SLR Ref No.: 610.033319.00002-L03-v2.0-20260602.docx

RE: 40-48 Redan St, Mosman
Response to Council Comments

In February 2026, SLR completed a waste management plan to support the state significant development application for a 54-apartment residential development at 40-48 Redan Street, Mosman (SLR reference 610.033319.00001-R01-v3.0-20260220).

40-48 Redan Street, Mosman 40-48 Redan Street Mosman NSW 2088		Level 2 Plan GA Floor Plans		Rev	Date	Description	By	Chk	Scale	Code	Sheet	Rev	0 2.5 5 10m	
				C	23/6/2026	RTS Lodgement	PP		1:250 @ A3	TPRS	2104	C

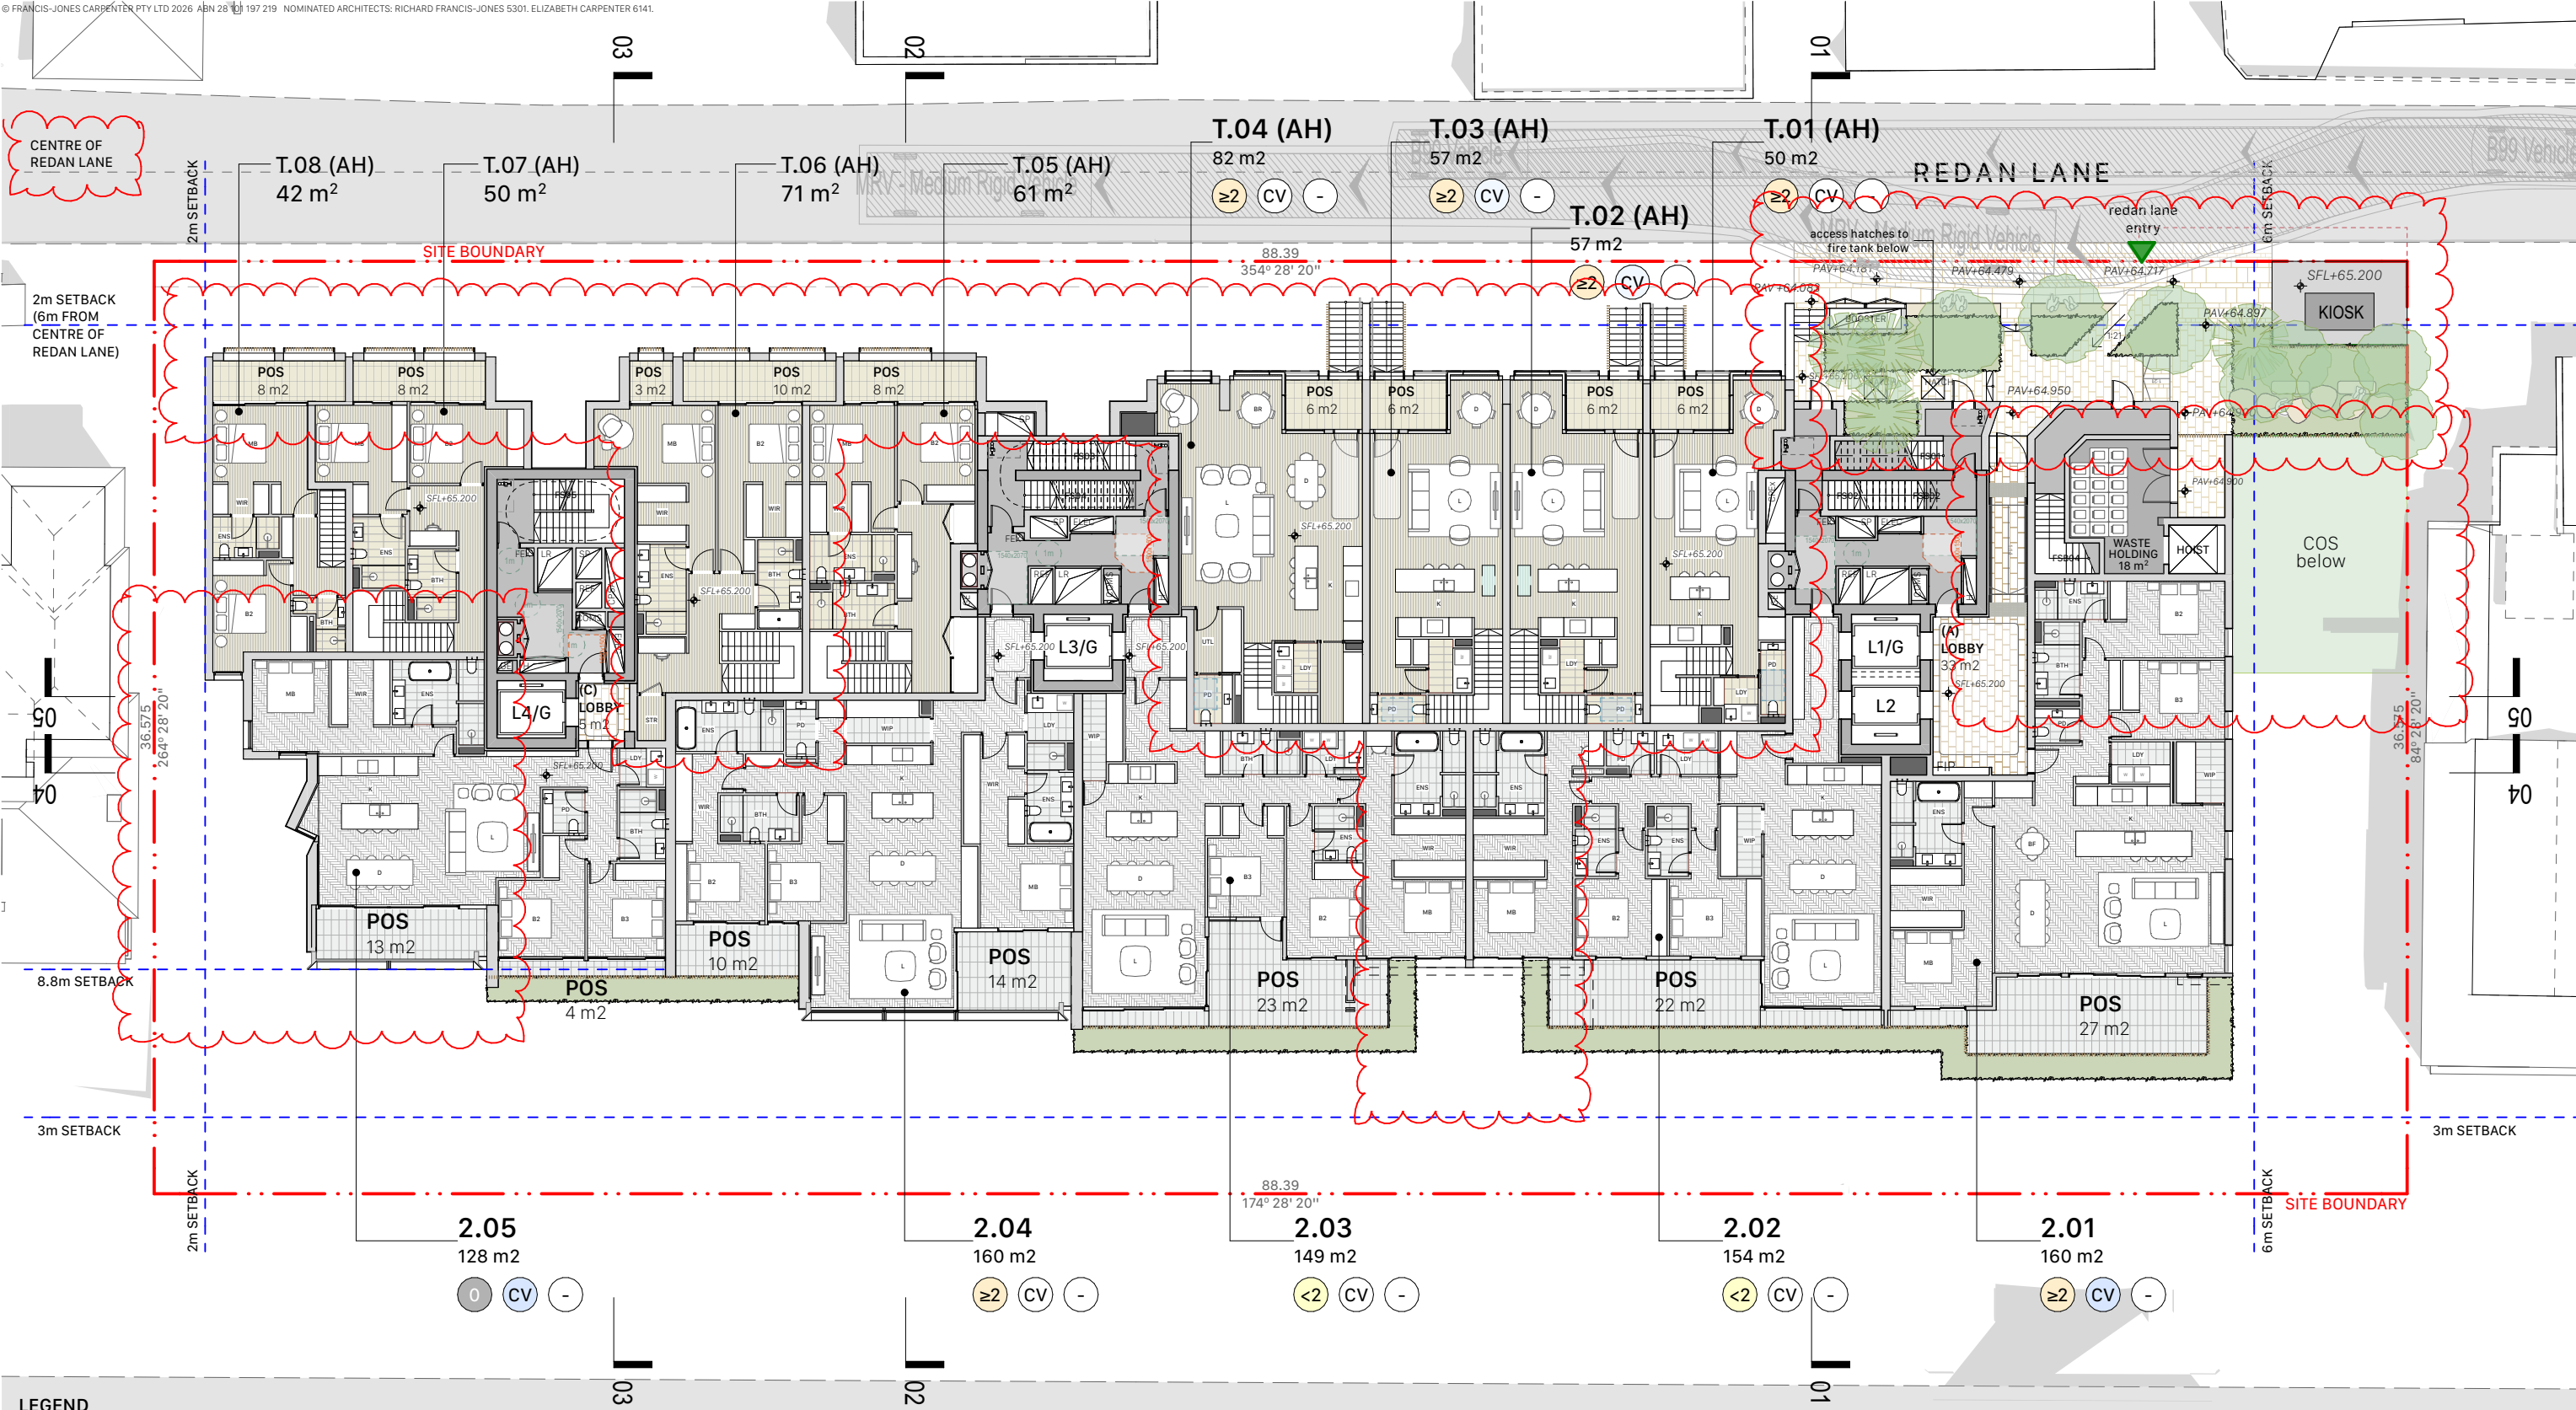
- The waste holding area is directly adjacent to the COS, which may result in adverse amenity issues, and further design details are required to show how this would appear from the public domain*

- *Show the number of bins to be held within the bin rooms, and to be collected on Redan Lane, on the architectural plans.*

Amendments have been made to the location and position of the waste holding room access door to improve the amenity and streetscape interface. The waste holding area is screened behind a solid wall and is fitted with self-closing doors. It is not possible to see the waste holding area from the COS.

On collection day, building management will transport the bins from the waste holding room on level 2 to the 'slip lane' in preparation for the waste collection vehicle, avoiding common areas and COS. Figure 4 below shows the path of travel from the waste holding room to the collection point is direct, a distance of about 6 m.

Figure 5 below shows bins in the waste holding room.

40-48 Redan Street, Mosman	Terraces Travel Paths	Rev	Date	Description	By	Chk	Scale	Code	Sheet	Rev
40-48 Redan Street Mosman NSW 2088	Supplementary Drawings	C	23/6/2026	RTS Lodgement	PP		No Scale @ A3	TPRS	9001	C

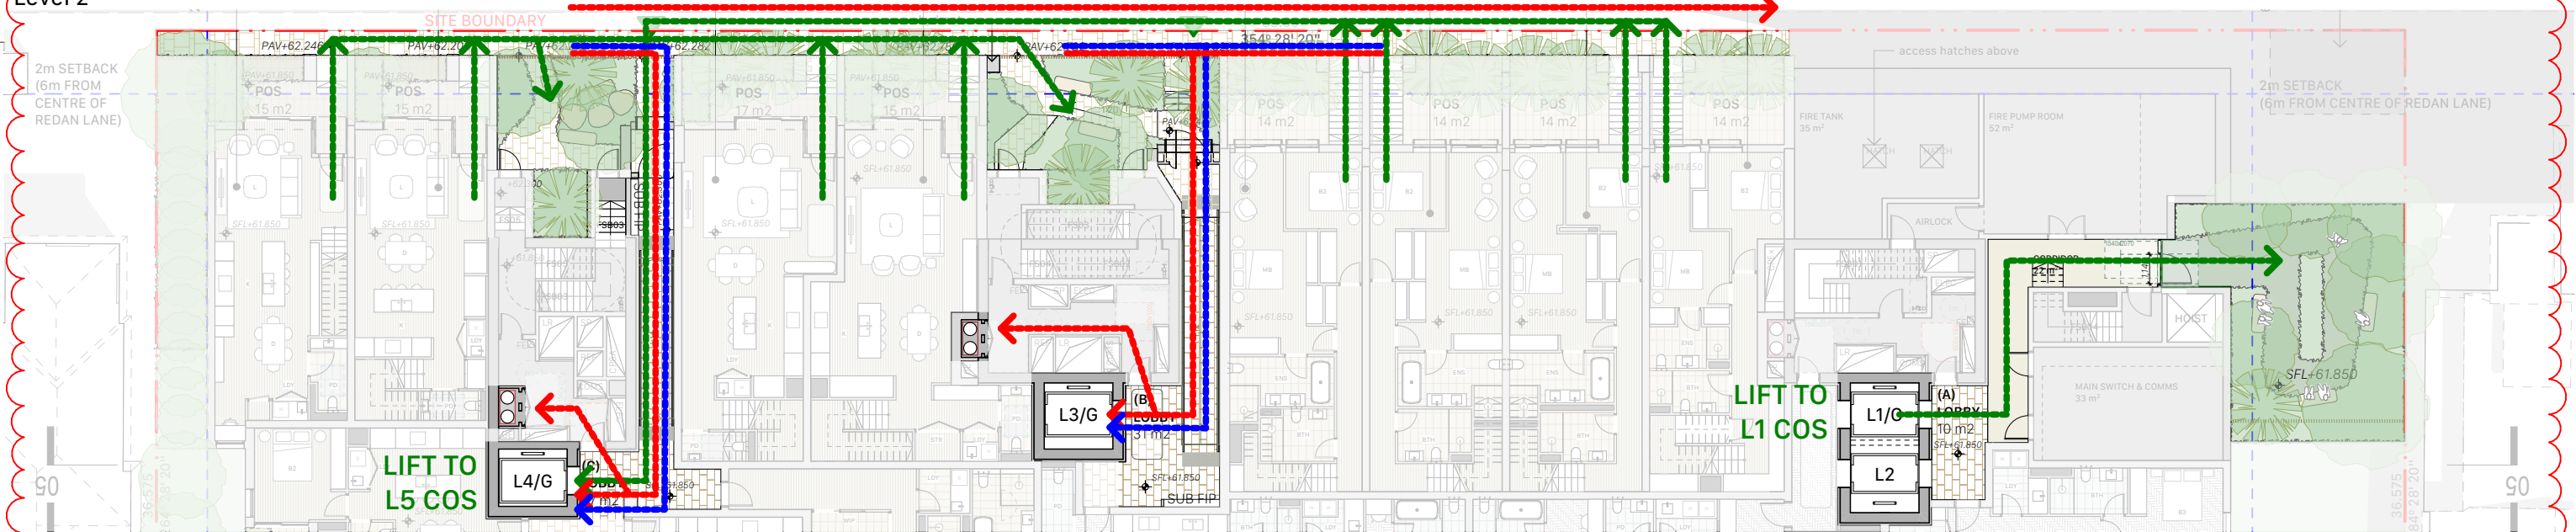
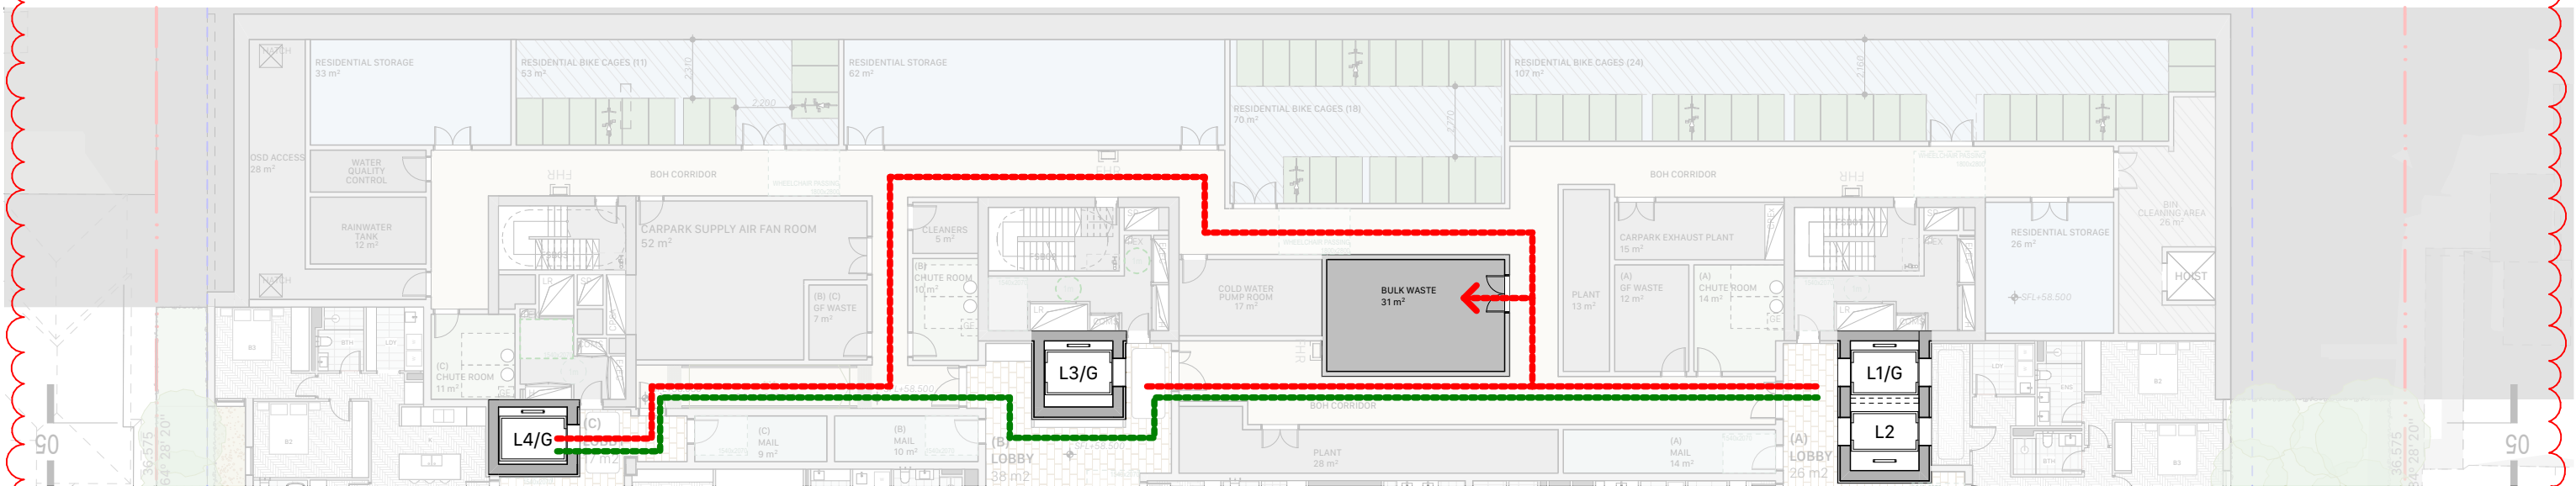
- The affordable housing units (T.01 -T.08) do not have direct access to bin storage rooms, requiring residents to travel via the public footpath to access to either the basement bin storage room, or through the communal open space (COS) to the waste holding area*

- *Paths of travel for waste bins to be transported for collection (avoiding common areas, including the COS)*

This statement is incorrect, residents of T.01-T.08 have access along a private pathway that is entirely within the development boundary. This path is not public and is only used by T.01-T.08 residents. T.01-T.08 are terraces and do not have any internal access whether it is to the car park or waste areas. Instead T.01-T.08 have direct access to the street.

Having said that, the strategy for how terrace residents access waste facilities has been reviewed, and at the request of DPHI, travel path diagrams have been prepared. These are attached to this letter. In summary:

- All terraces will have access to the waste holding room located on Level 2.
- T.08-T.05 will also have access to lobby C chutes.
- T.04-T.03 will also have access to lobby B chutes.
- T.02-T.01 will also have access to lobby A chutes.
